A Comments on REP2-030 Applicant's response to Written Representations

B Comments on REP2-029 Applicant's response to ExAQ1

Figure 15-2

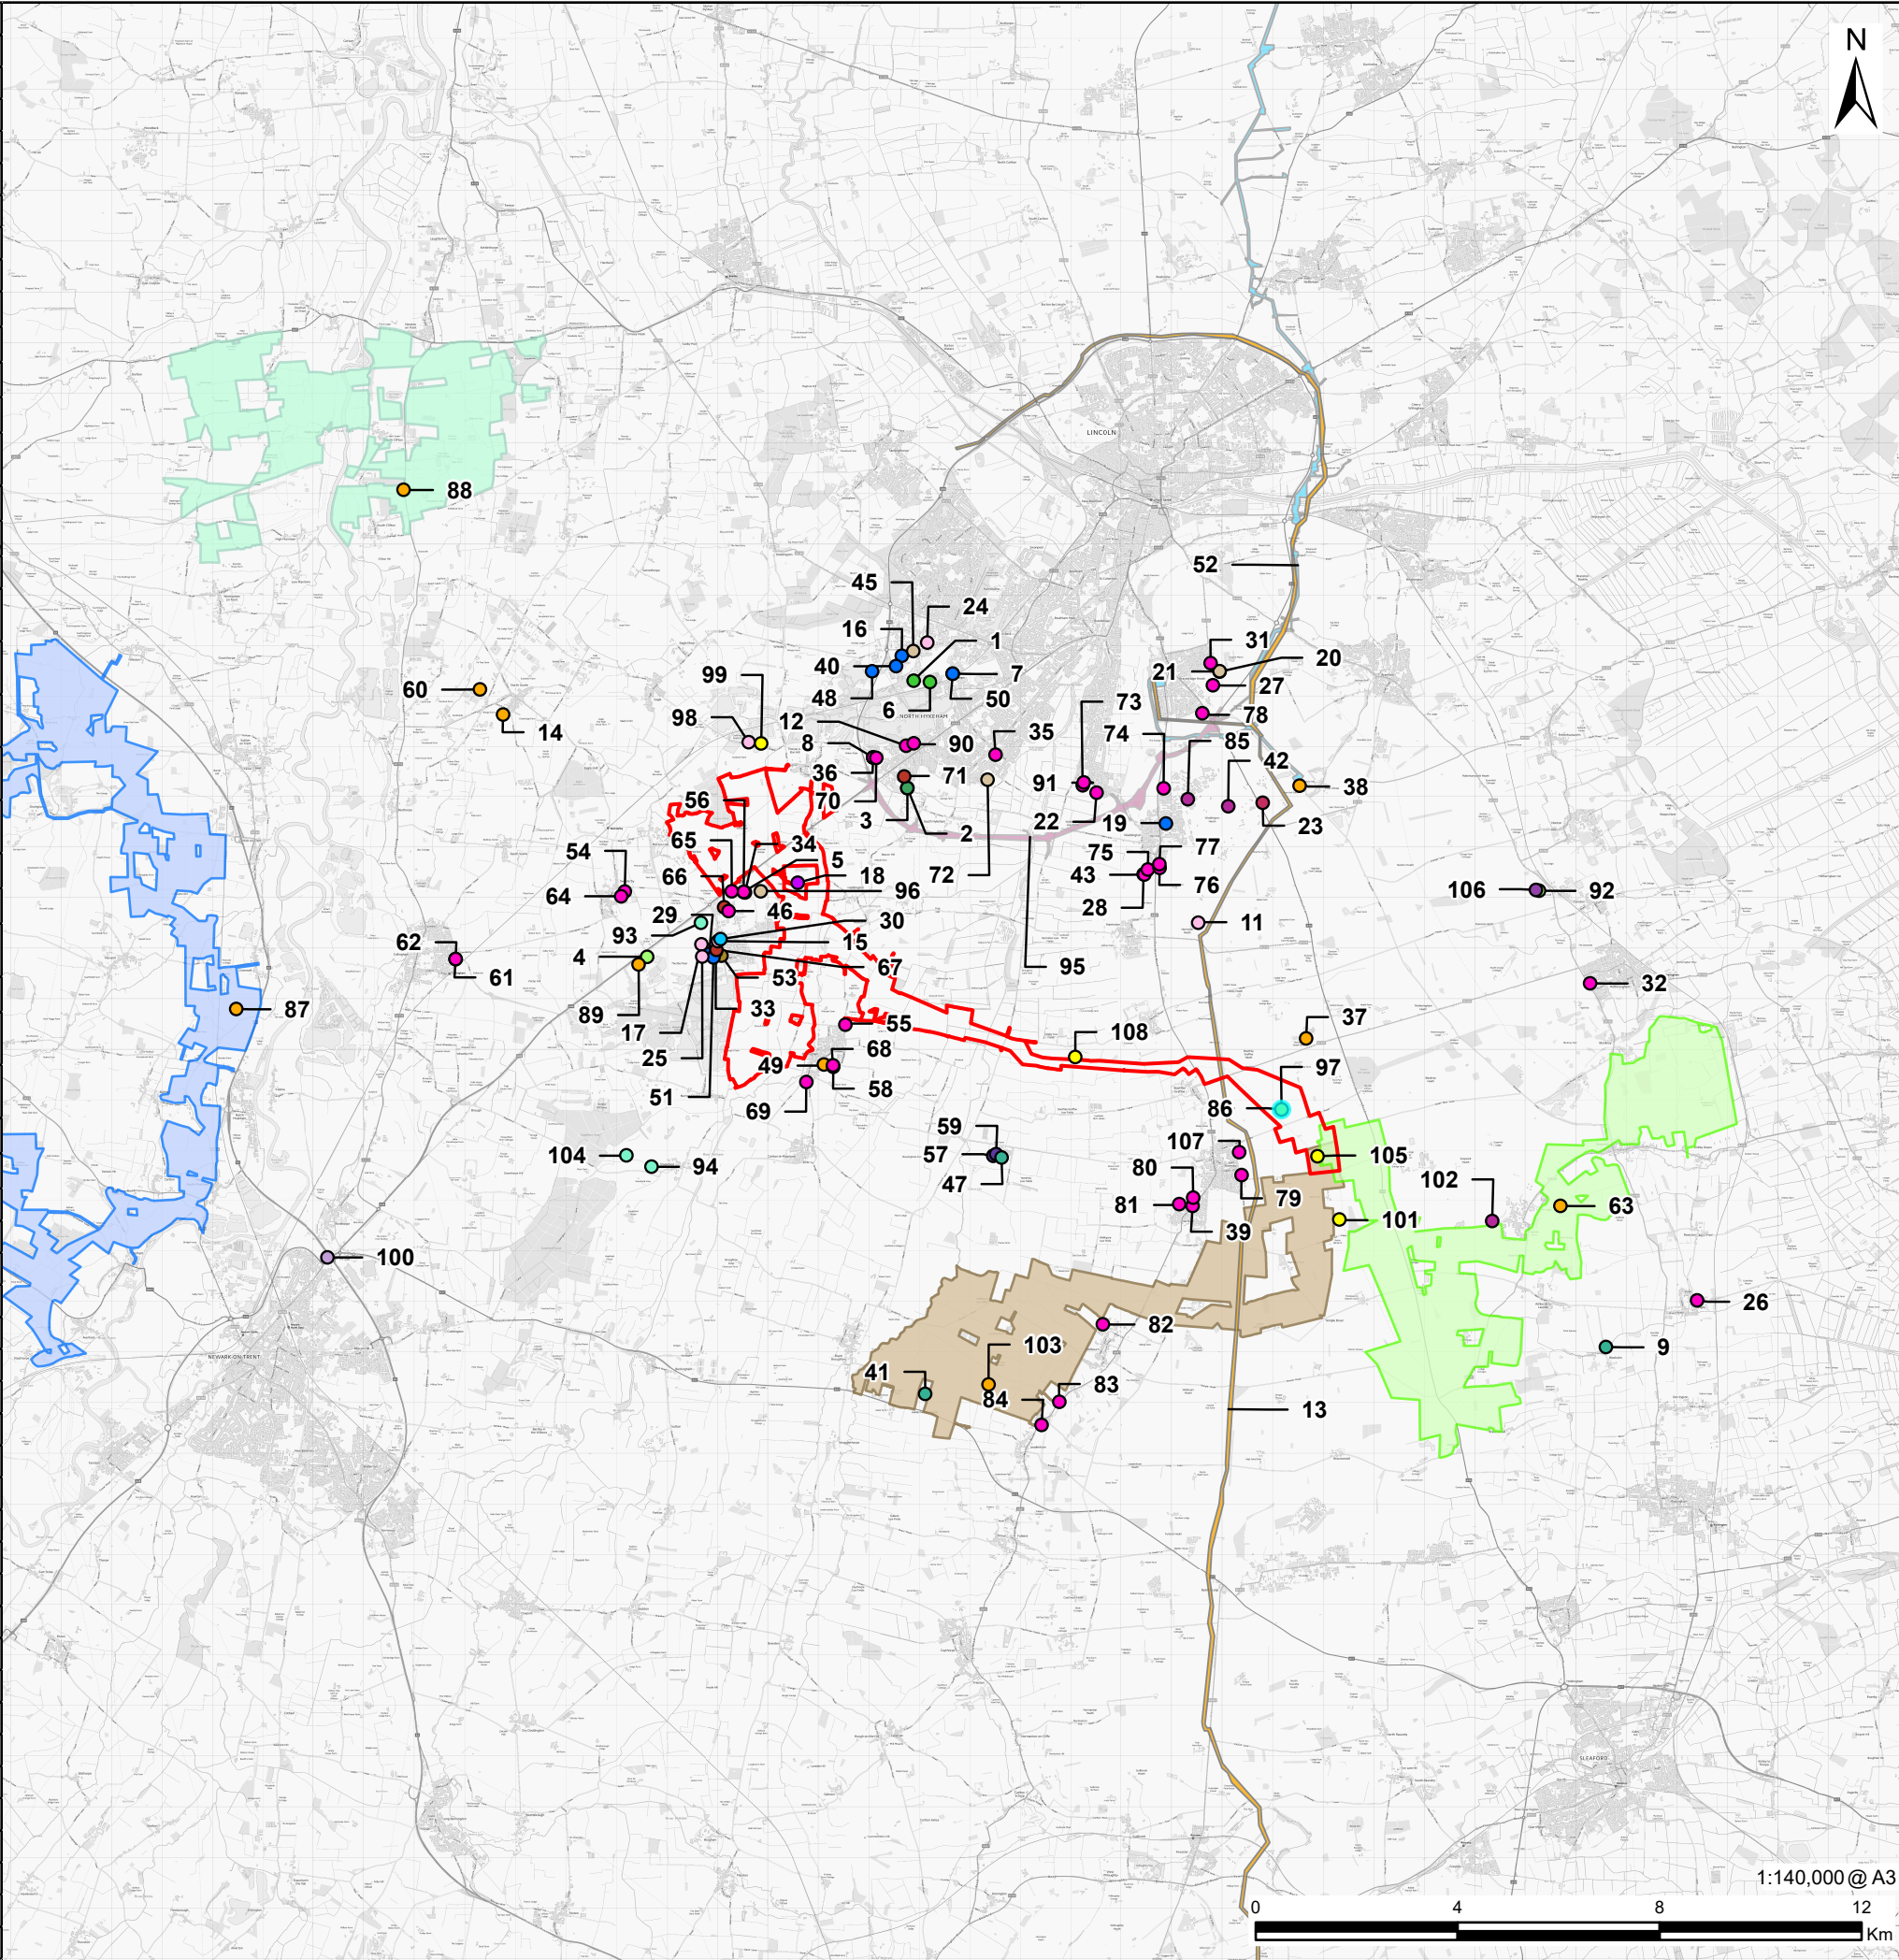
4.2.1 Paragraph 12.10.5 of Chapter 12 Socio-Economics and Land Use (APP-040) sets out a list of 25 schemes taken from the short list of developments and which were taken into account in assessing the cumulative impact of other developments on the proposed development in that chapter. Whilst the Brant BESS Scheme was listed in the shortlisted developments in Chapter 15 and shown on Figure 15-2, it was specifically not included in the final list of 25 schemes which were included in the cumulative assessment in Chapter 12. It is not correct therefore that the Applicant has scoped the Brant BESS scheme into the

assessment and as the Applicant admits it should have been included, the assessment is therefore defective.

4.2.2 The Screening Opinion 23/0584/EIASCR and Scoping Opinion 23/0584/EIASCO for a 400MW BESS on the north side of Green Man Road, Navenby do not form part of the planning application 25/491/FUL for the proposed BESS on the south side of Green Man Road, Navenby and cannot be said to be part of the Navenby BESS scheme. Whilst the Applicant may be relying on the Screening and Scoping Opinions to support their planning application for the proposed BESS on the south side of Green Man Road, the Screening and Scoping Opinions relate to a different site. At the public consultation event on 13 November 2024 in relation to the proposed BESS on the south side of Green Man Road, the Applicant stated that it could pursue a planning application for one or both of the sites either side of Green Man Road. Both sites should have been separately included in the list of developments in paragraph 12.10.5 of Chapter 12 (APP-040).
